Subject: Environmental Impact Statement – Bullecourt Avenue, Milperra - Early Works and Stage 1 (SSD-97092958) (Canterbury-Bankstown)

CPHR advice on EIS – Bullecourt Avenue, Milperra - Early Works and Stage 1 (SSD- 97092958) (Canterbury-Bankstown)

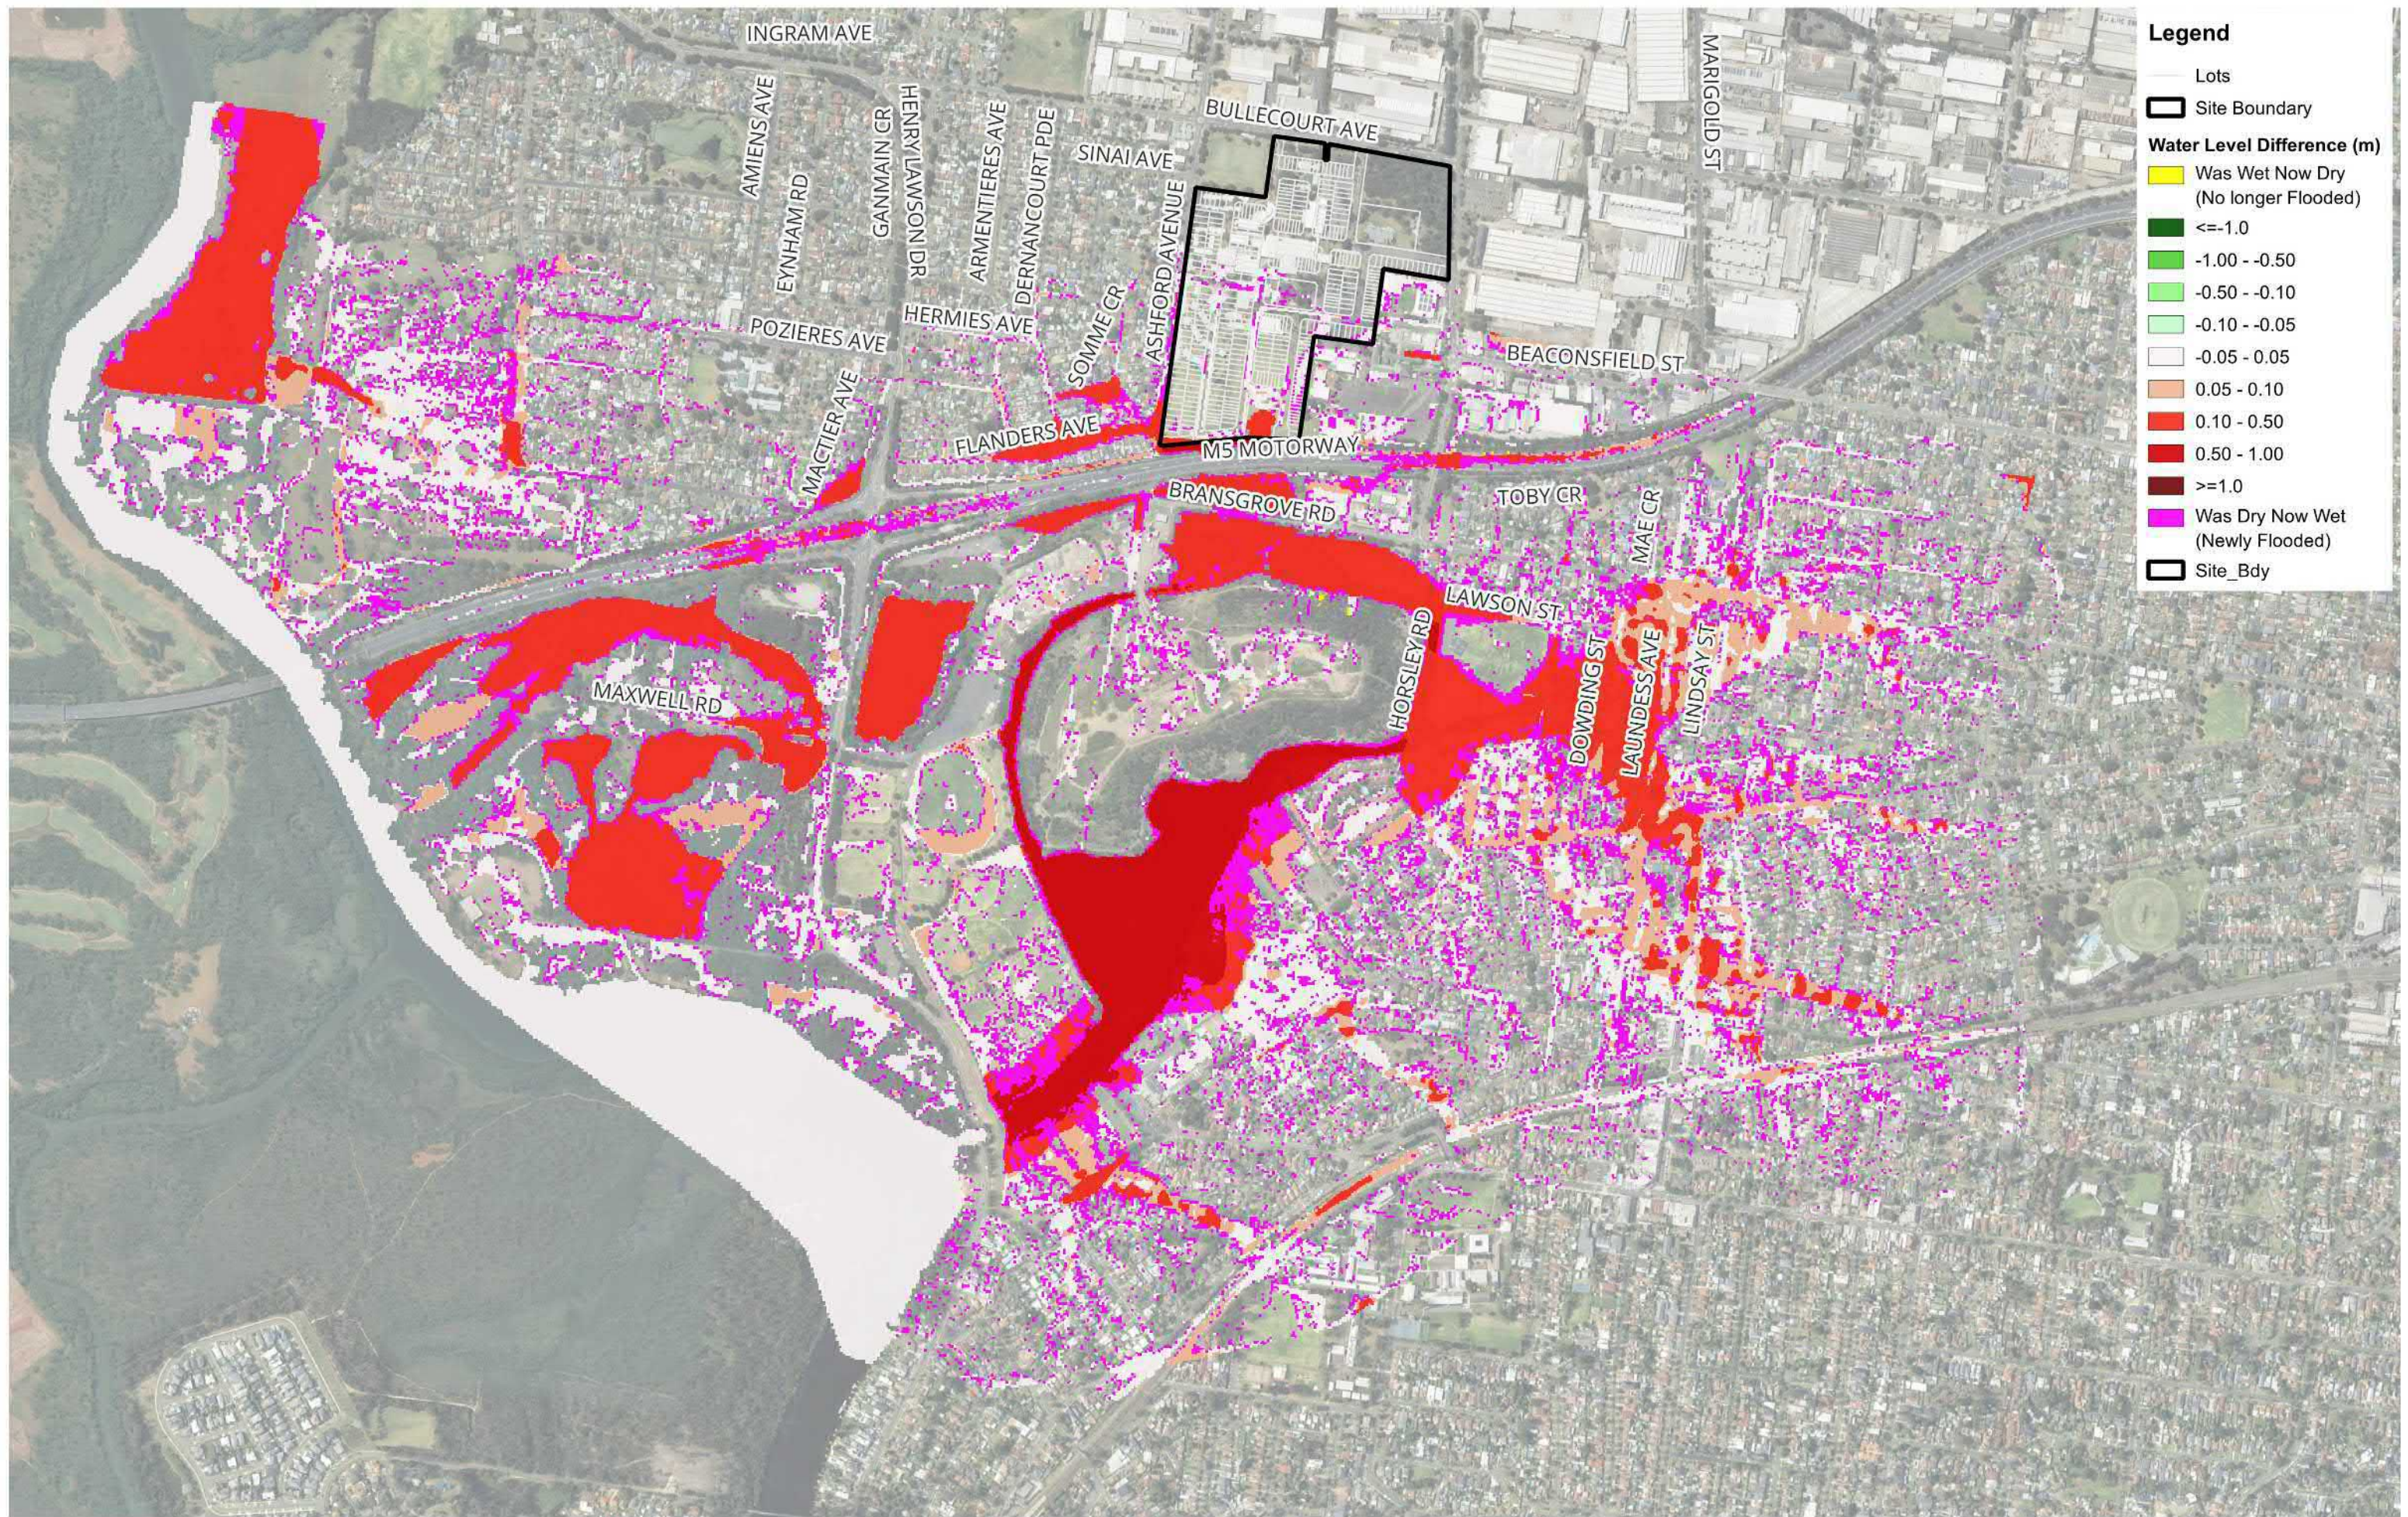
4.	Emergency management	The FIRA proposes off-site self-evacuation as the primary emergency management strategy which is facilitated by an internal road network that provides rising access to flood-free land. However, CPHR's review of the flood hazard mapping indicates that one internal street is subject to high flood hazard (H5) during the probable maximum flood (PMF). Under H5 conditions, vehicle access would be unsafe and residents who have not evacuated prior to flood hazard reaching H2 would become isolated. CPHR notes that the flood hazard mapping was derived using general flood hazard vulnerability curves which provide a practical and widely adopted tool for assessing hazard levels for people, vehicles, and buildings by using a single consolidated set of curves. CPHR advises that a more detailed assessment of an individual hazard category is required. The Flood Risk Management Guideline FB03 Flood Hazard (FB03 guideline) provides separate vulnerability curves for people, vehicles and buildings. For example, the current application of the general hazard curves may overstate the risk to vehicles, as the mapped H5 hazard along the affected internal road is associated with shallow flood depths of less than 0.25m. Under these conditions, the use of vehicle stability thresholds in the FB03 guideline would provide a more appropriate assessment of vehicle trafficability and feasibility of emergency evacuation. Recommended action: Revise the FIRA to address the emergency management requirements by referring to stability thresholds in the FB03 guideline. The following options are to be considered in the revised FIRA: • <u>Option 1</u> - Demonstrate that all evacuation routes are safe for vehicles in all flood events up to and including the PMF.

• <u>Option 2</u> - Demonstrate that sufficient warning time is available to allow all residents to self-evacuate off-site before internal roads become non-trafficable. • <u>Option 3</u> - Demonstrate that any residents who are unable to evacuate prior becoming isolated can safely shelter in place for the full duration of the PMF event.
	<i>Extent and Timing</i>	Response to Submissions
